Re: Application A99/14/HH

I wish to object to this resubmission. The application (A/46/14/HH) was previously refused and the reasons for refusal are still valid.

DRAWING TITLE
EXISTING FRONT BOUNDARY WALL
ELEVATIONS, PLAN AND SECTION

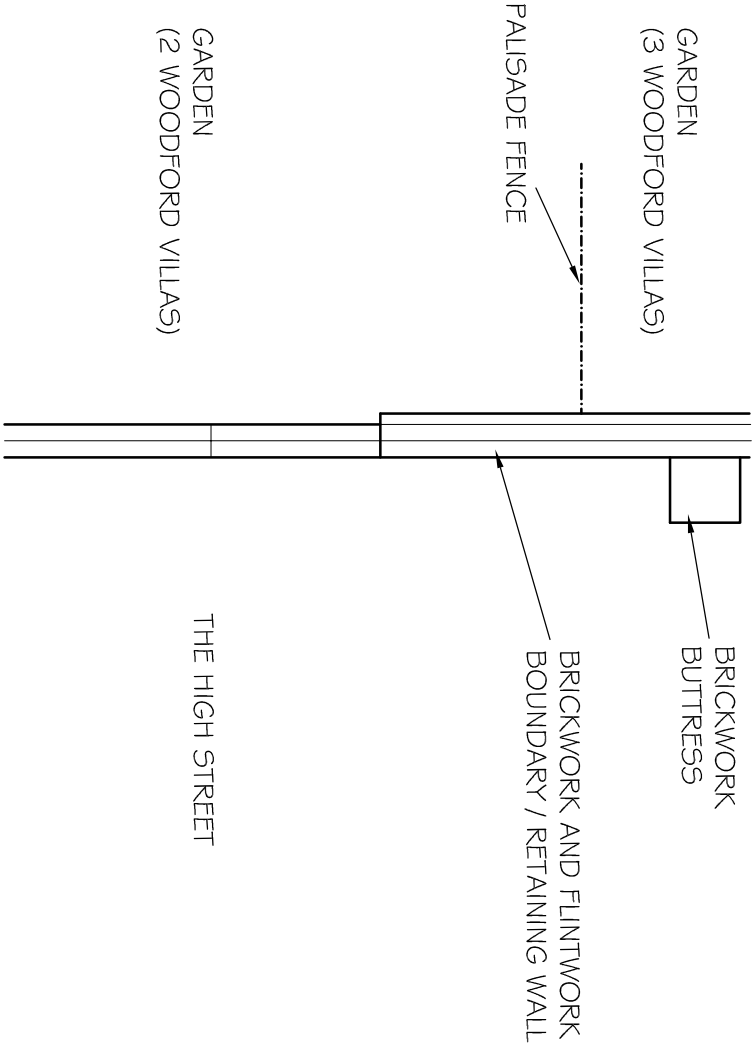
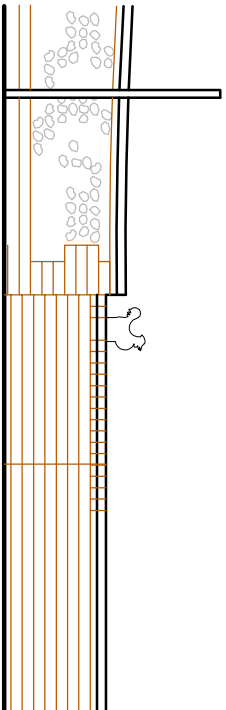
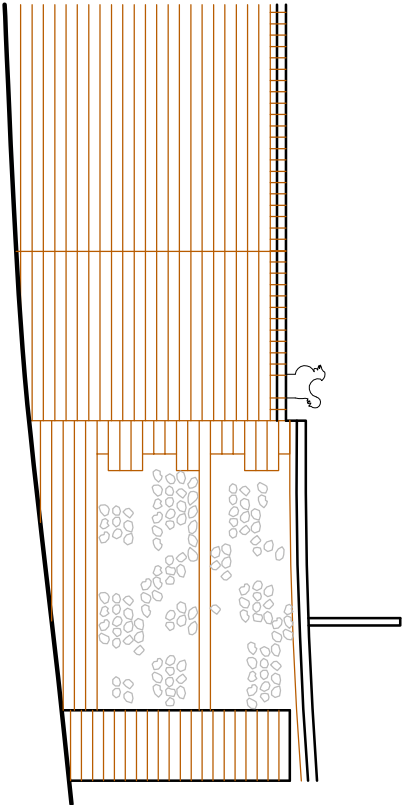
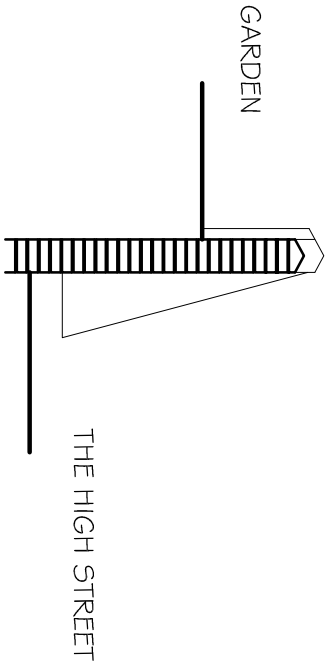
Namely that the brickwork and terracotta chicken are not in keeping with the appearance of the conservation area. The brick work is of very poor quality and does not match the existing wall.

It also removes shared steps to 5 other properties, access being granted previously for a shared pathway.
